From: Rebekah Allen <beckya@pprbd.org>
Sent: Tuesday, December 29, 2020 8:25 AM
To: Survey Mike; Brent Johnson; jeffrey Vignery
Cc: Lindsay Darden
Subject: RE: Woodlake Filing No 1A Plat
Attachments: AD06003 SOFTWOOD 122820.pdf

WOODLAKE FILING NO.1A

A VACATION AND REPLAT OF LOTS 304 AND 305, WOODLAKE FILING NO.1
15735 & 15755 SOFTWOOD ROAD, ELBERT, CO, 80106

WOODLAKE FILING NO.1A

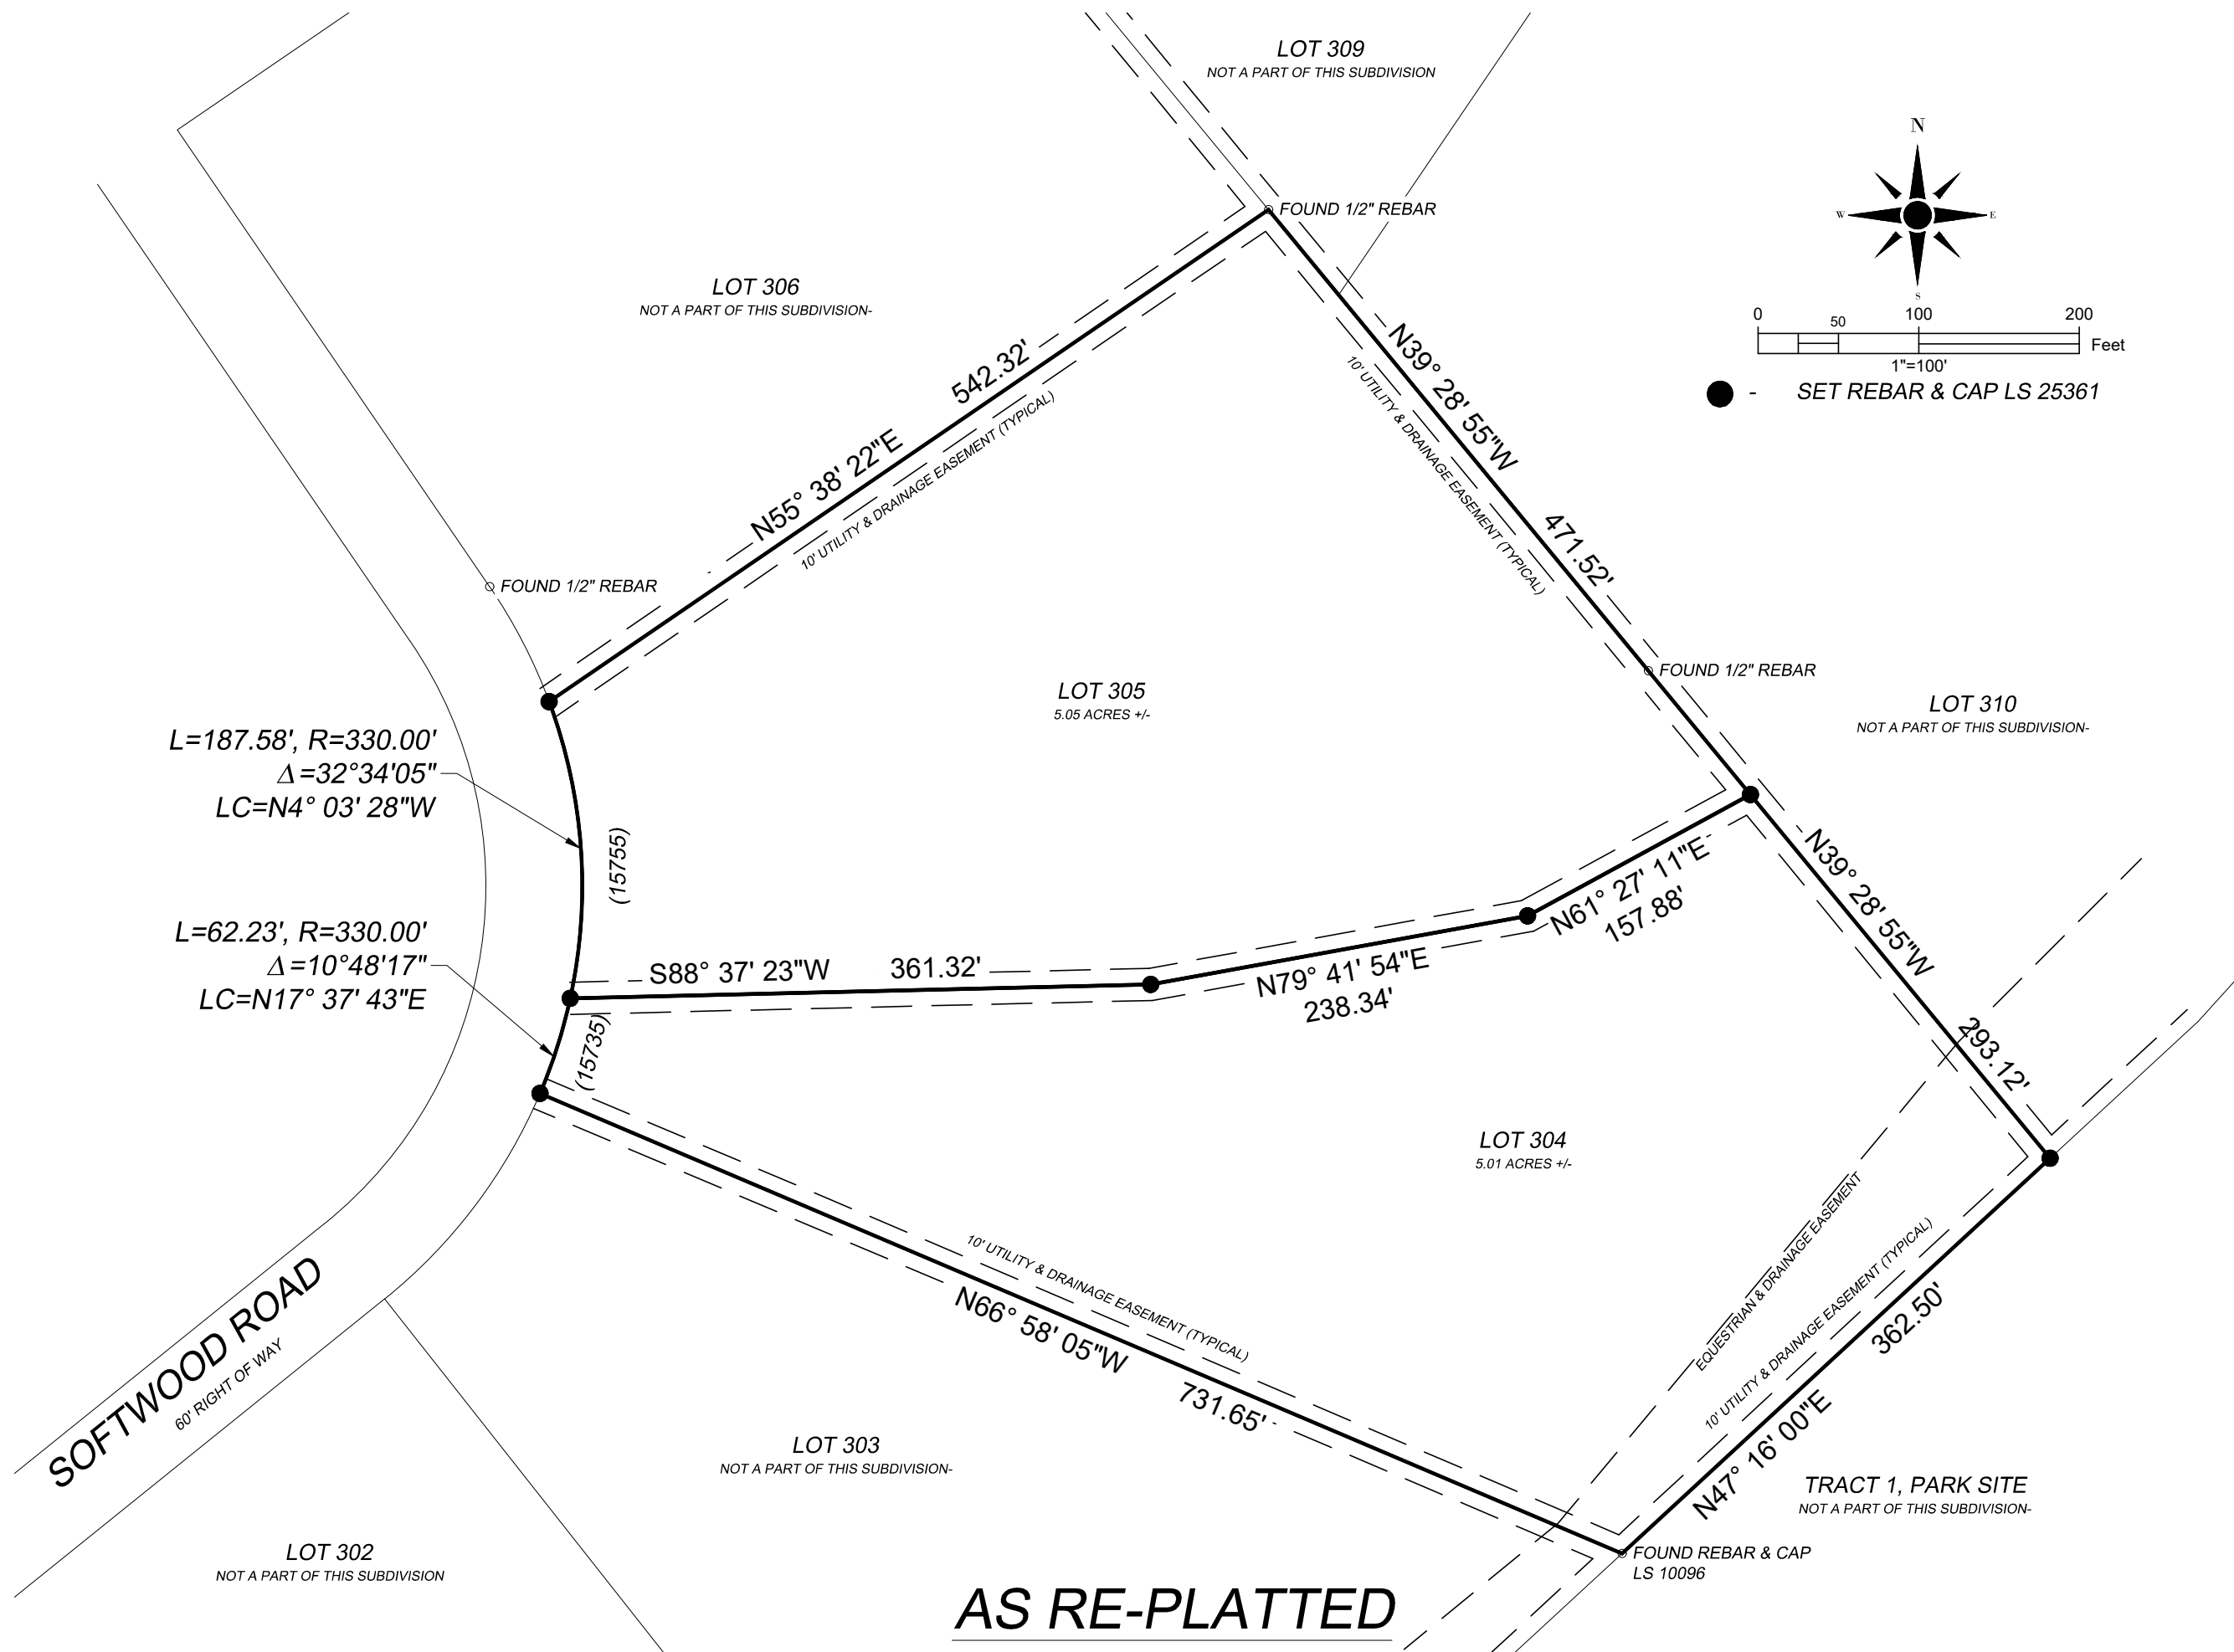
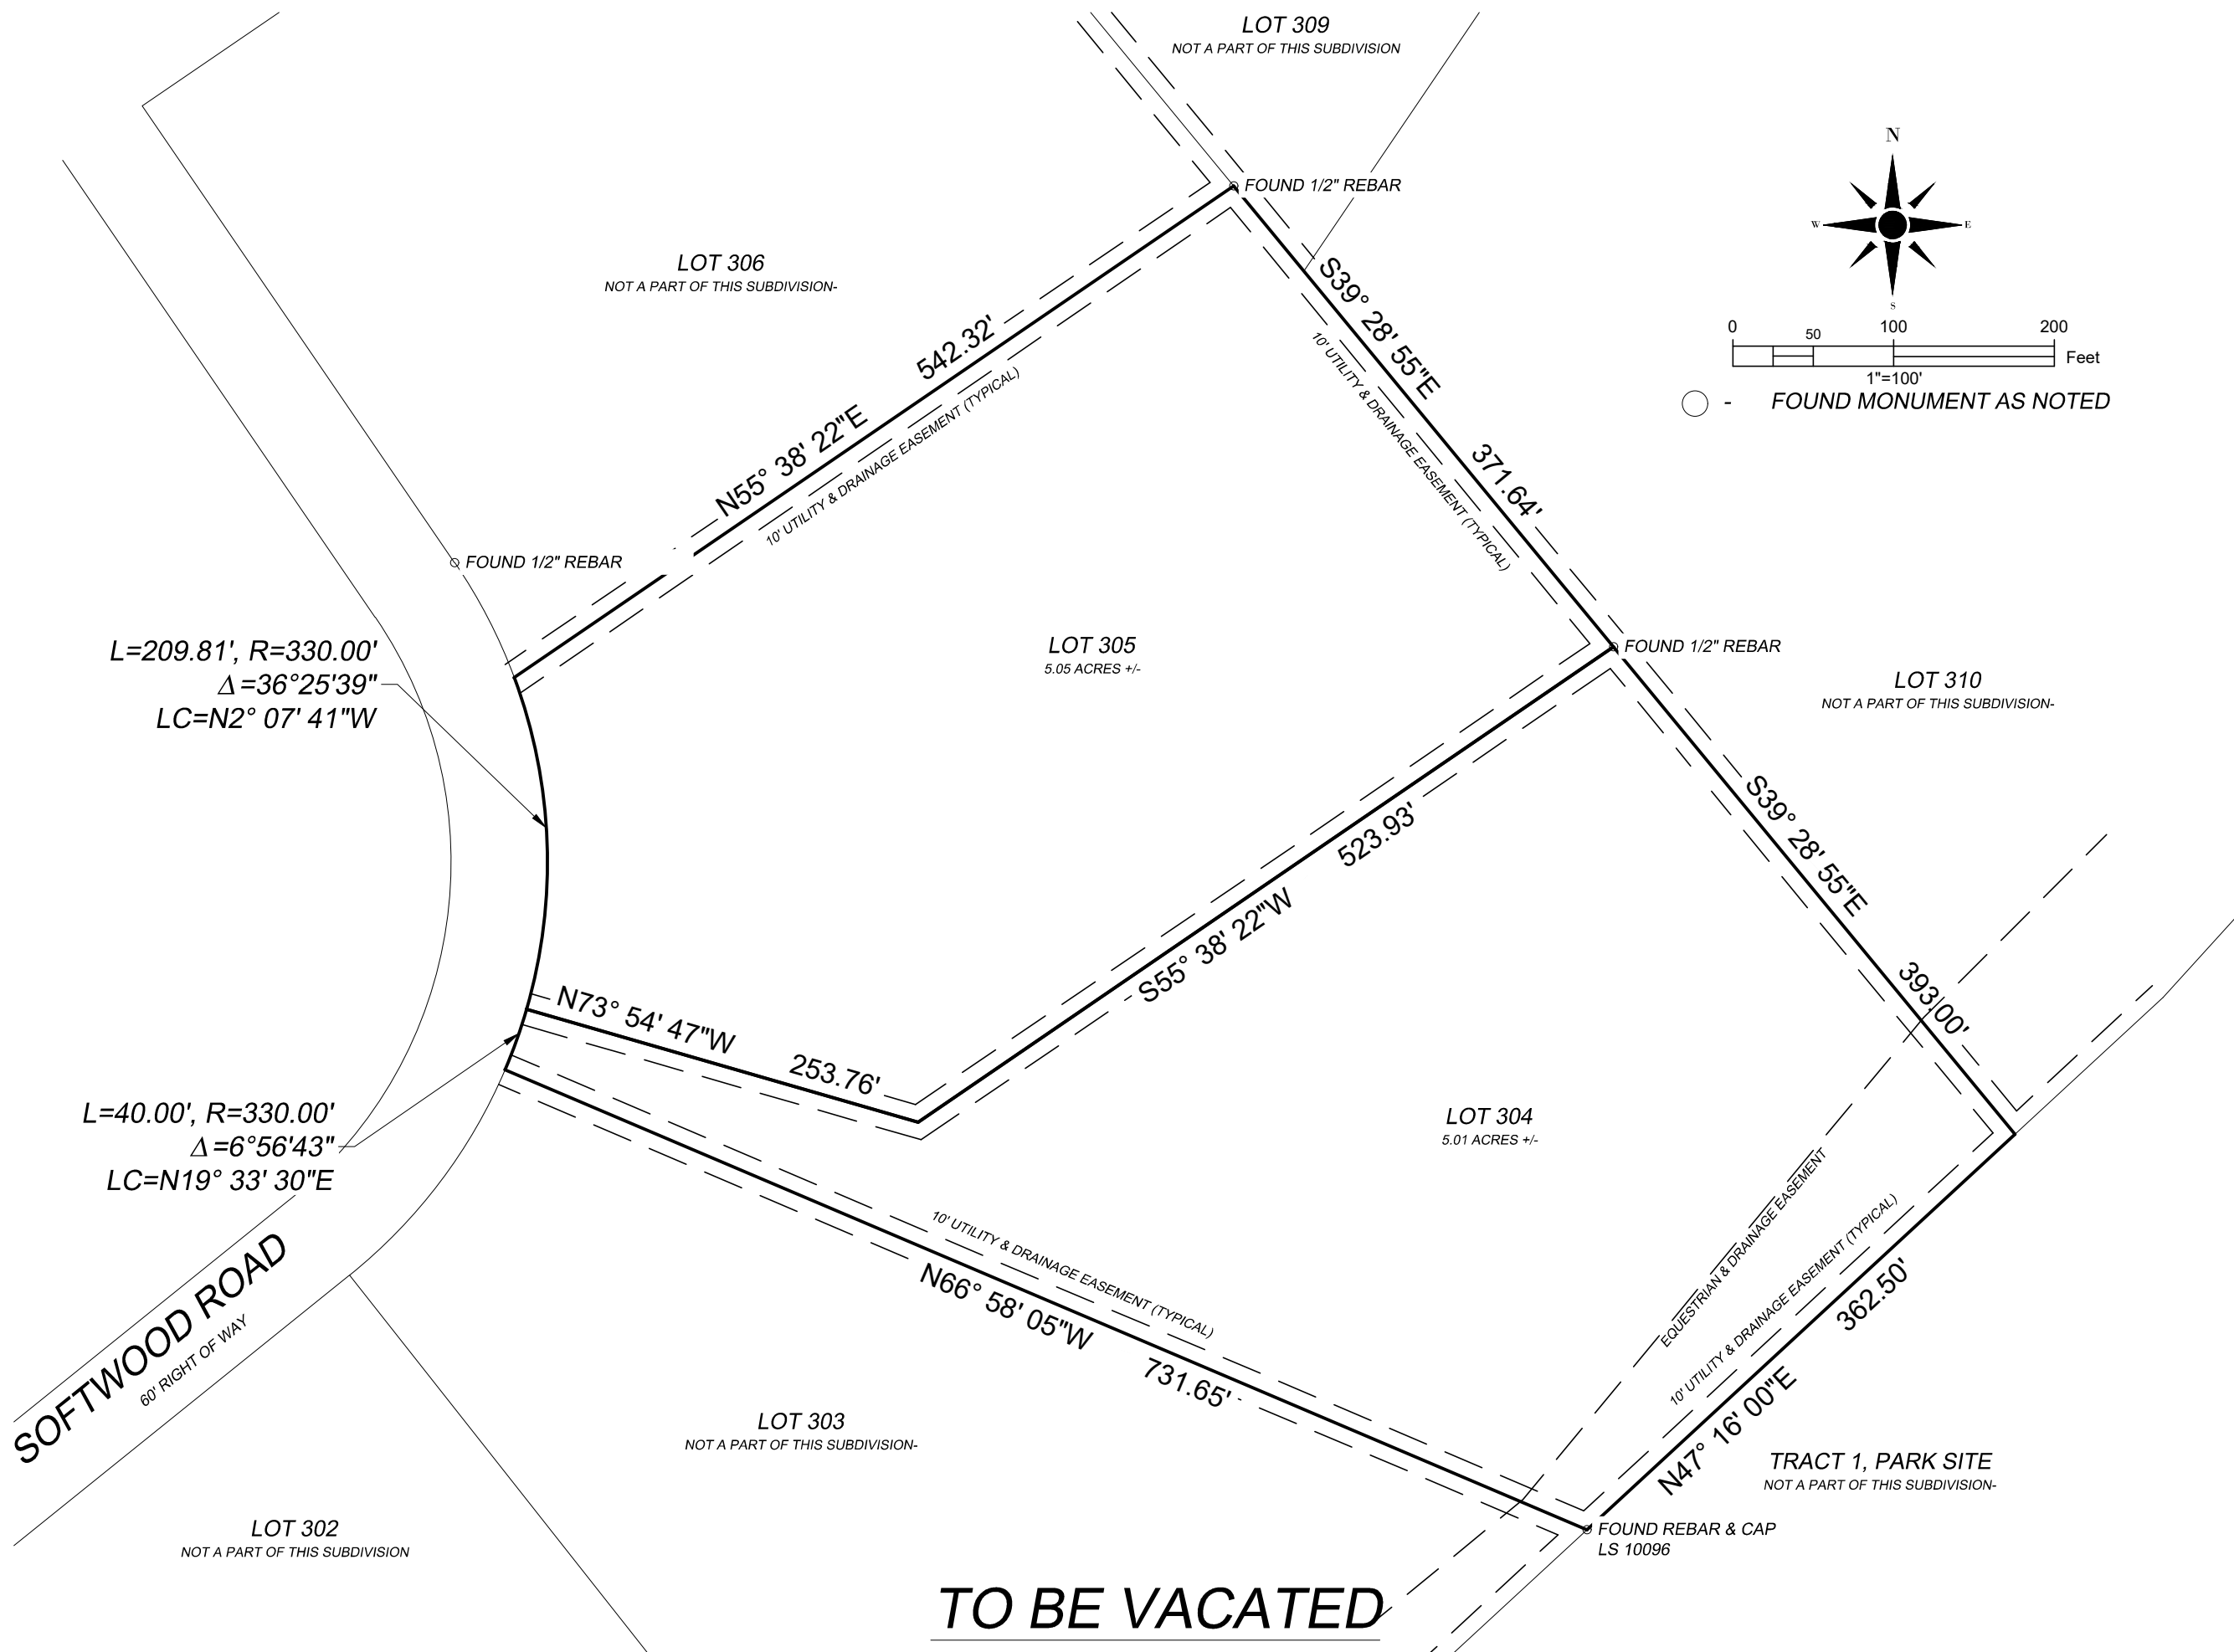
The addresses are required to be on each lot. Lot 304-15735, lot 305-15755 Softwood Road.
